Honeywood House,
The Street
Walberton
BN18 0PY

REF. WA/102/24/PL

OBJECTION TO THE ABOVE DEVELOPMENT AT LONGACRE, THE STREET, WALBERTON.

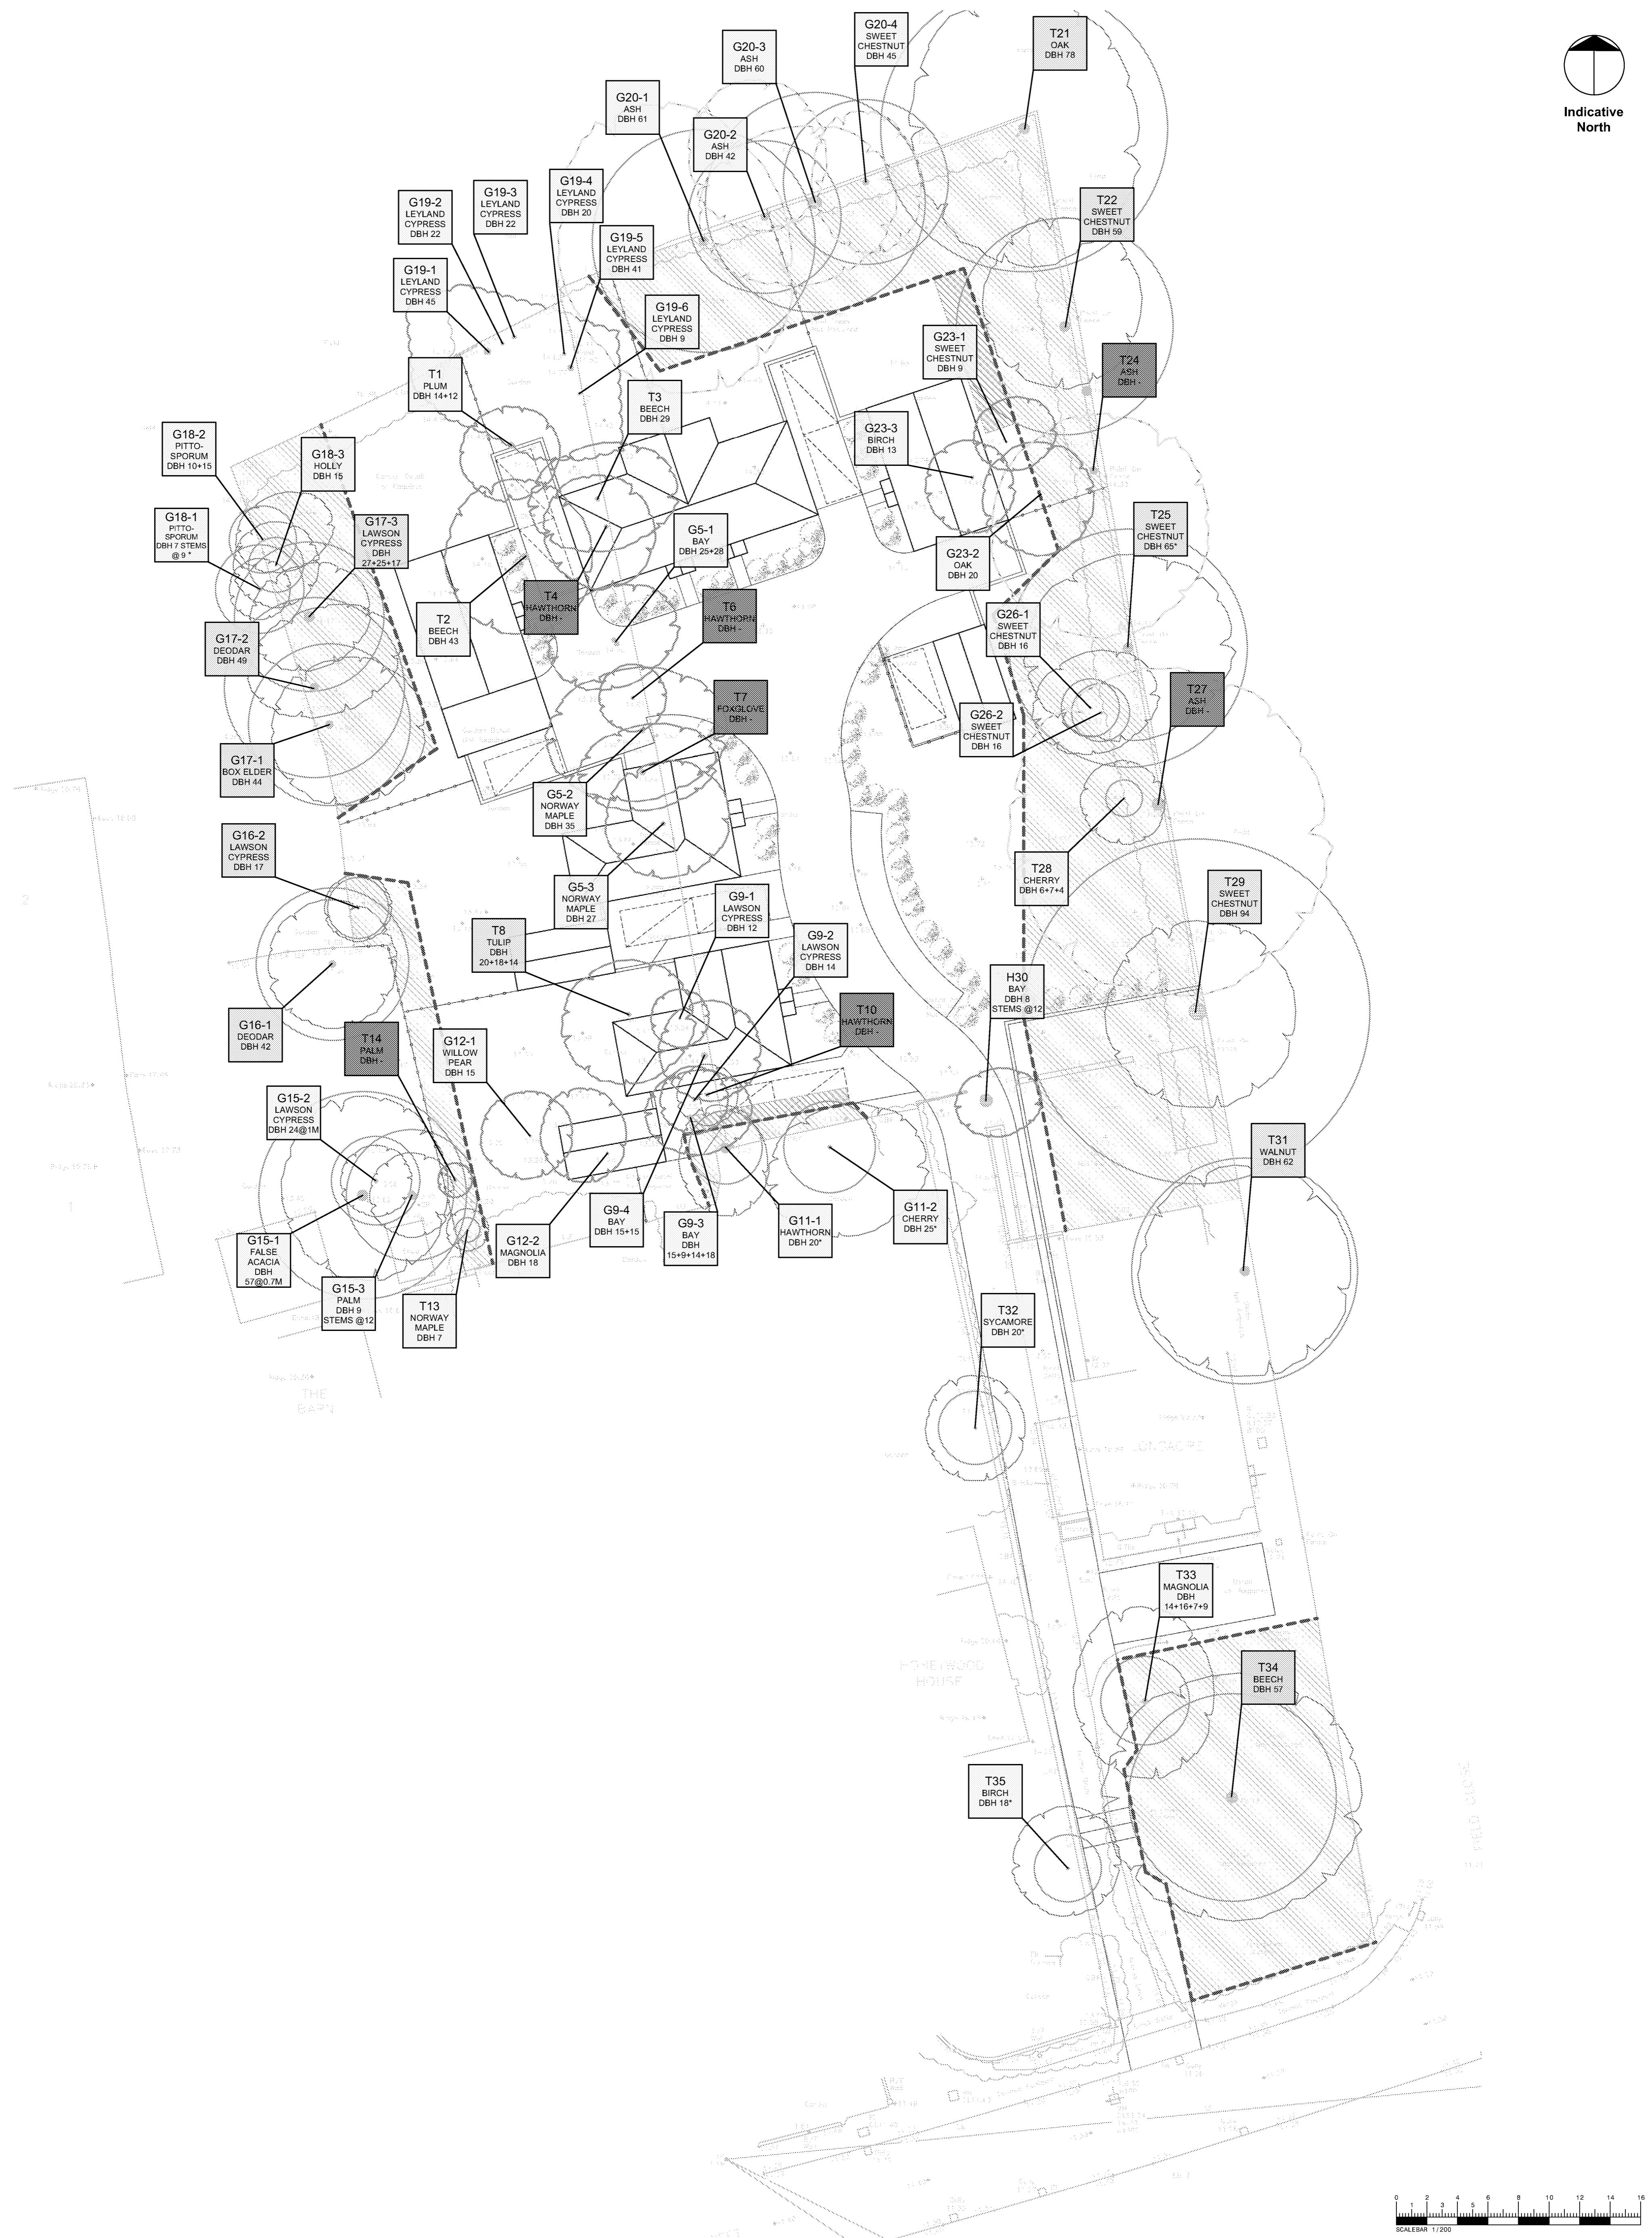
We note with interest the Tree Protection Plan commissioned by the developer. There are several trees on our side of the boundary, and we cannot believe that RPA's can be executed due to the restricted width of the access road. The tree roots will undoubtedly be immediately under the drive which is to be developed into a road. They will be compressed and killed by heavy construction traffic, The road will need curbs and excavation to put haunching under the curb stones will be quite deep. Any root of diameter 25mm or greater will need to be protected and retained. Again we do not imagine care will be taken The deep and extensive trenches needed for the utilities to be installed will also damage any trees and shrubs nearby.

DETAIL 1 - NEW ACCESS ROAD - TYPICAL SECTION

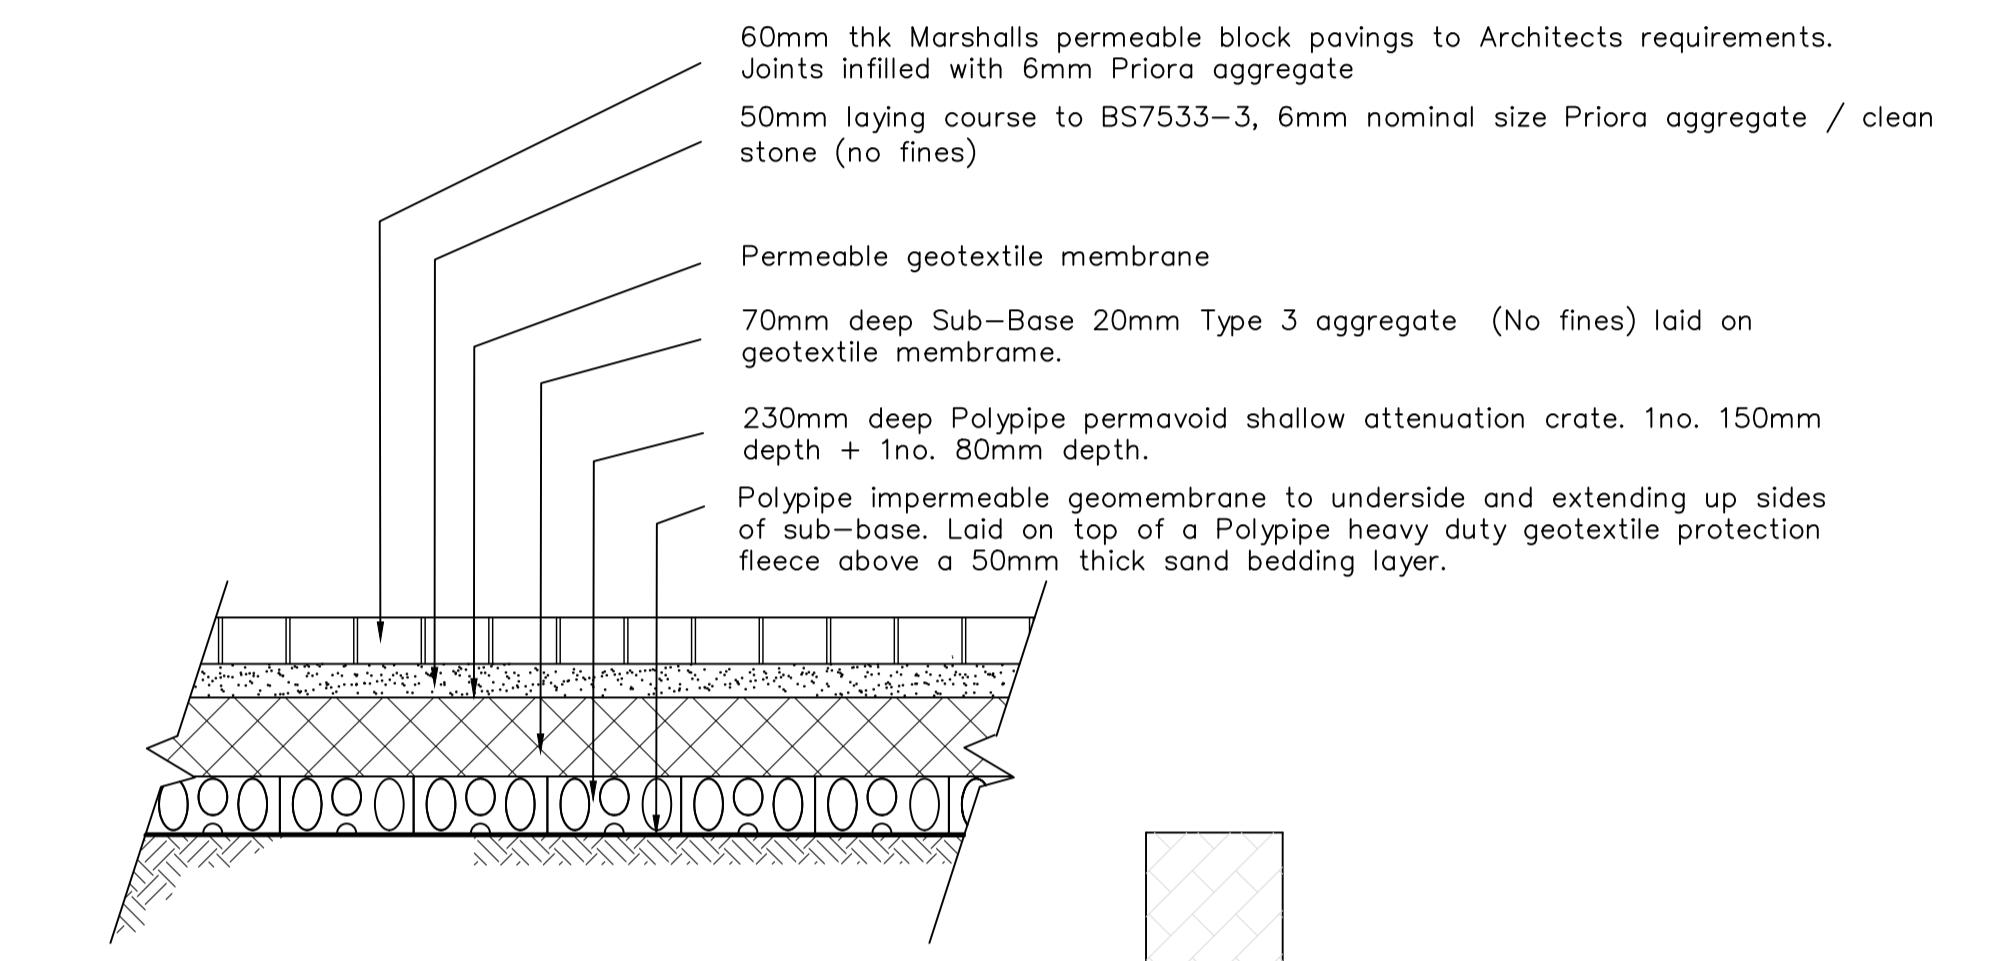
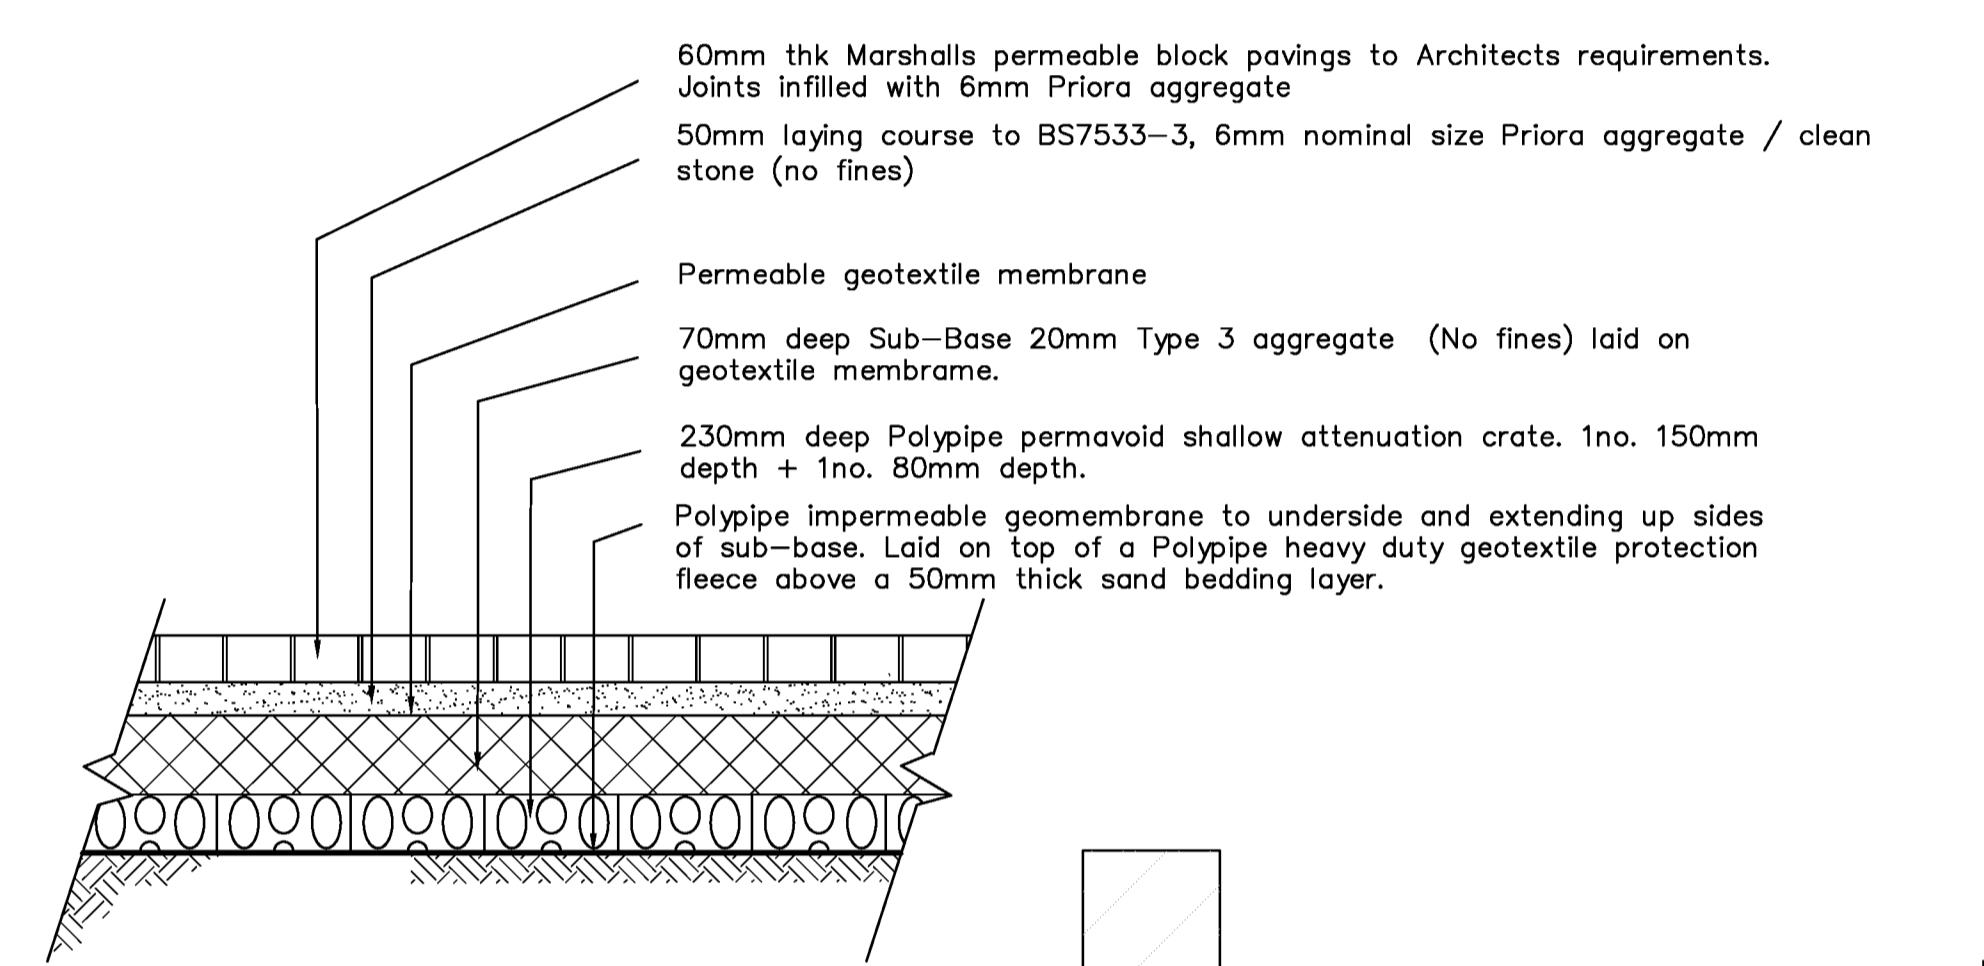
The current drive of Longacre is a fairly loose gravelled construction and clearly this will allow for some water to seep into the ground. The new road access to 6 dwellings will, we assume ,be of sturdier construction. It may well be a metalled or tarmac or block road which will cause significant peak surface run off. This will exacerbate the flooding in The Street. Please can we ask to see the strategy that the developers are proposing for the drive construction? We fear that we will experience run off from the new development through our garden . It already gets very waterlogged.
